Please ask for: Nicola Moore
Email: nicola.moore@arun.gov.uk
Telephone: Ext 37944
Our Ref: CM/36/21/CLP
Your Ref:
Date: 12th July 2021

Lawful Development Certificate for a Proposed Use or Development

Development: Lawful development certificate for the proposed change of use of existing outbuilding to habitable use and proposed change to internal staircase to spiral staircase and installation of kitchen and bathroom.

Location: The Barn Horsemere Green Lane Climping BN17 5QX

GROUND FLOOR

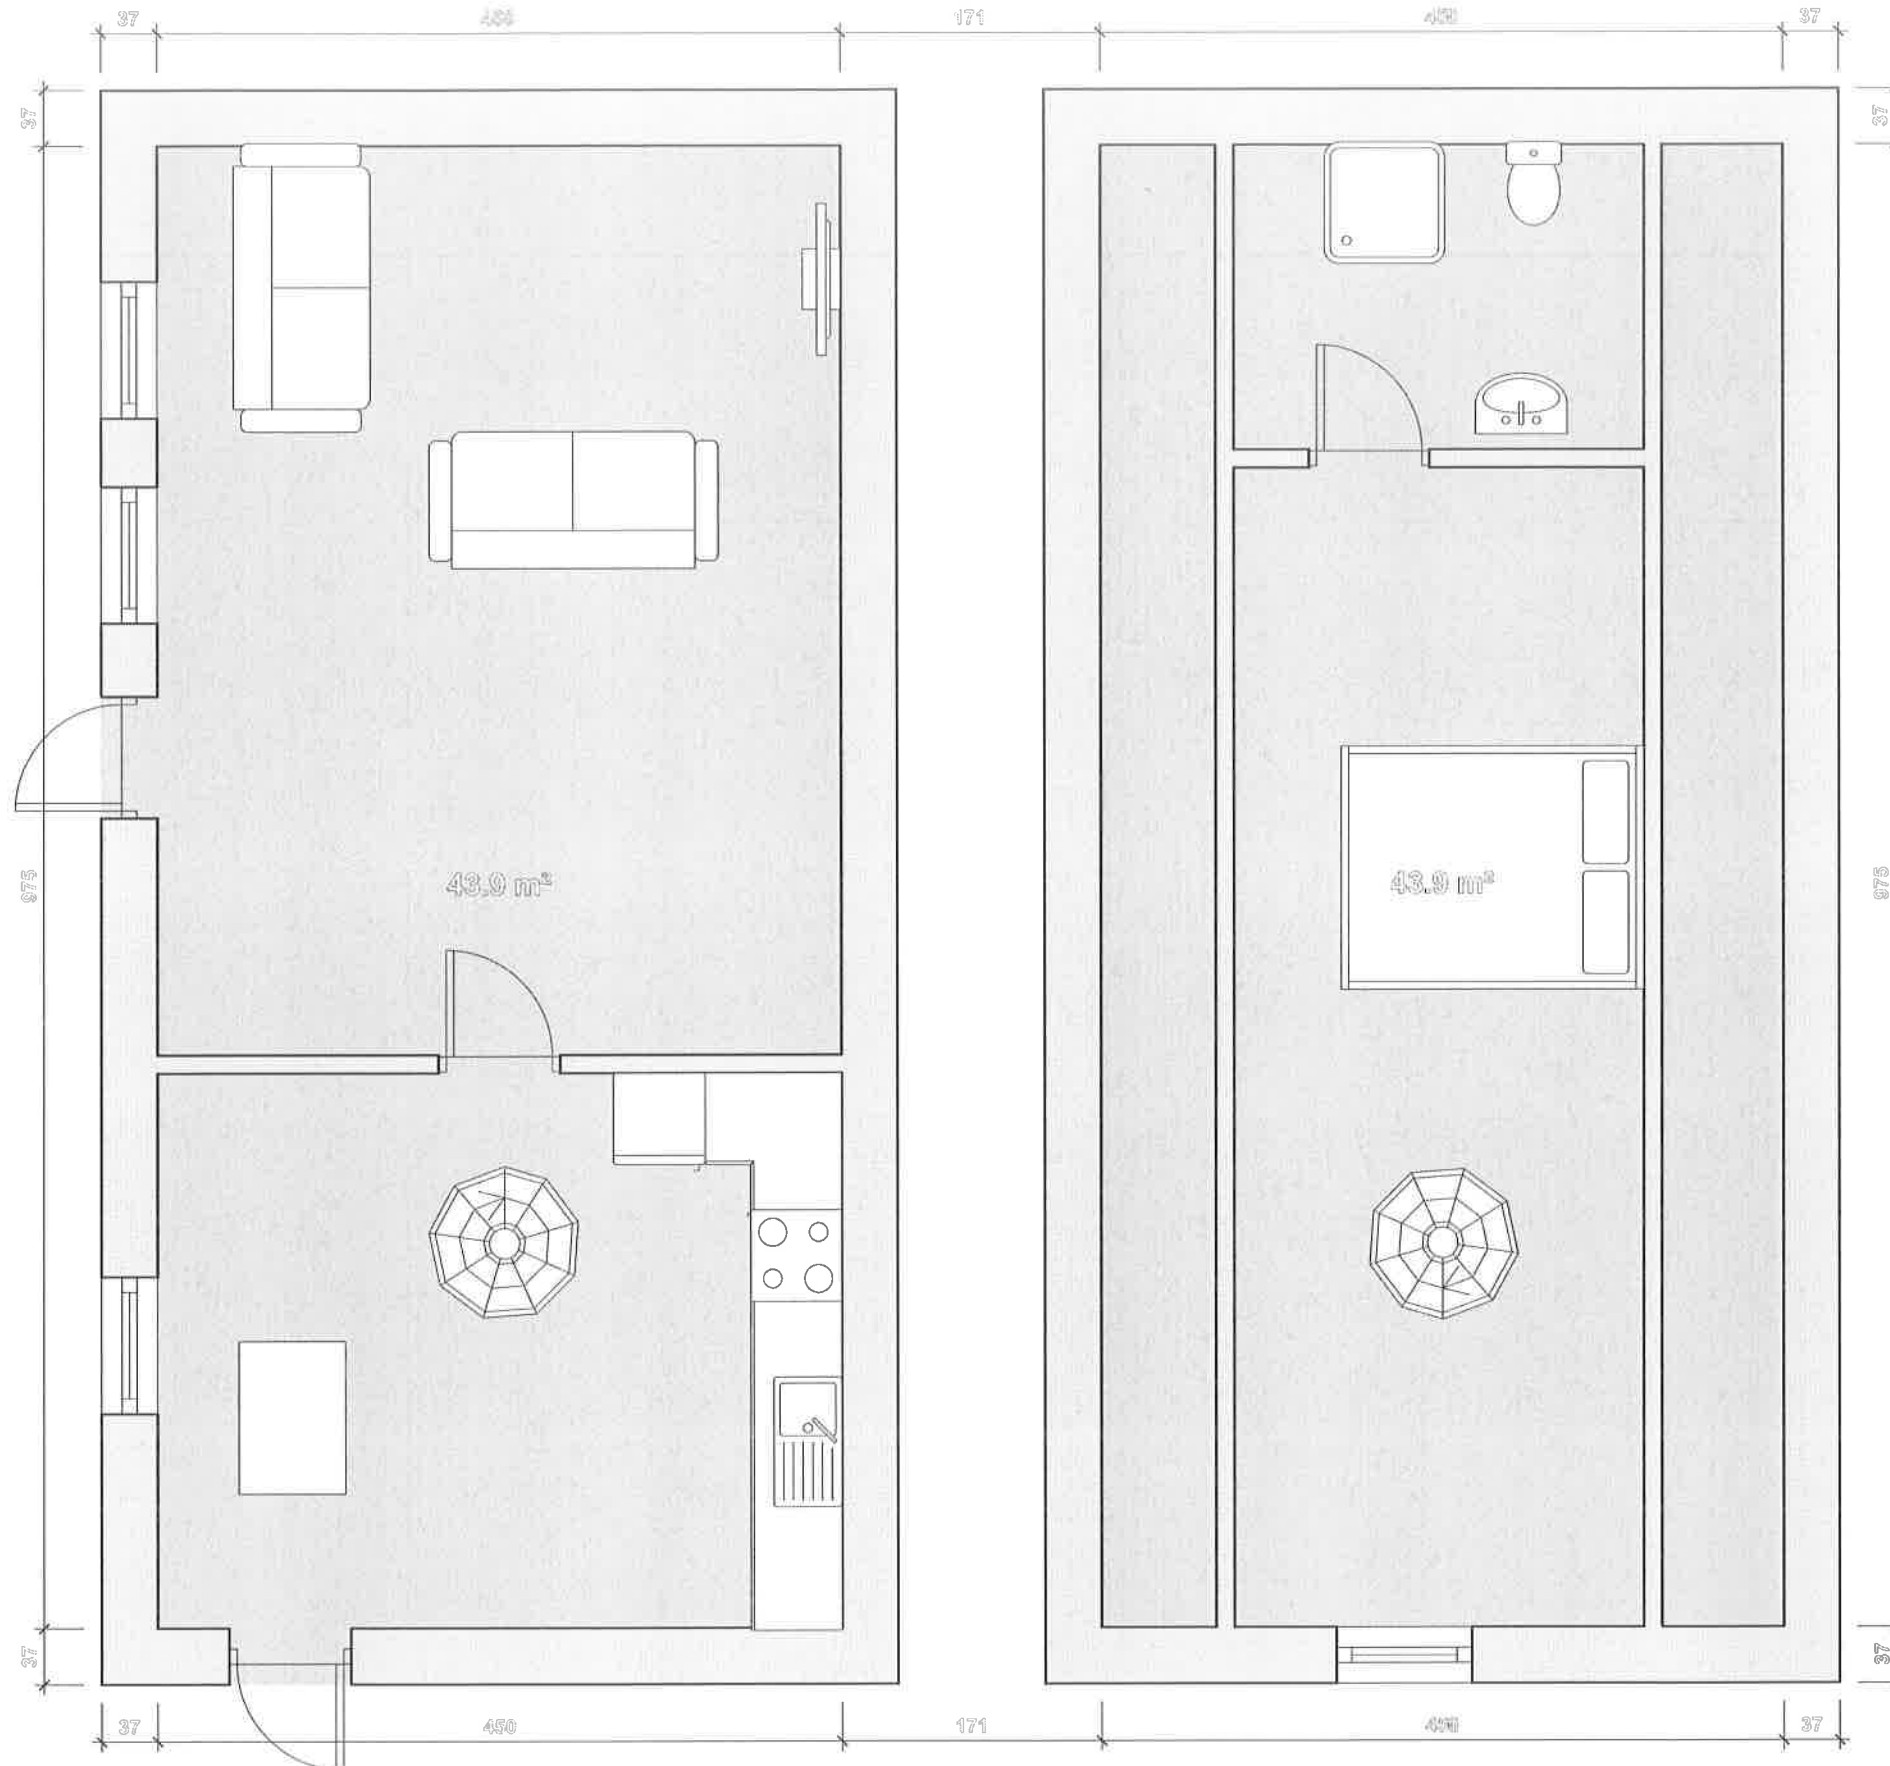
Please amend the submitted plans to show the scale or dimensions so that the room dimensions can be measured.
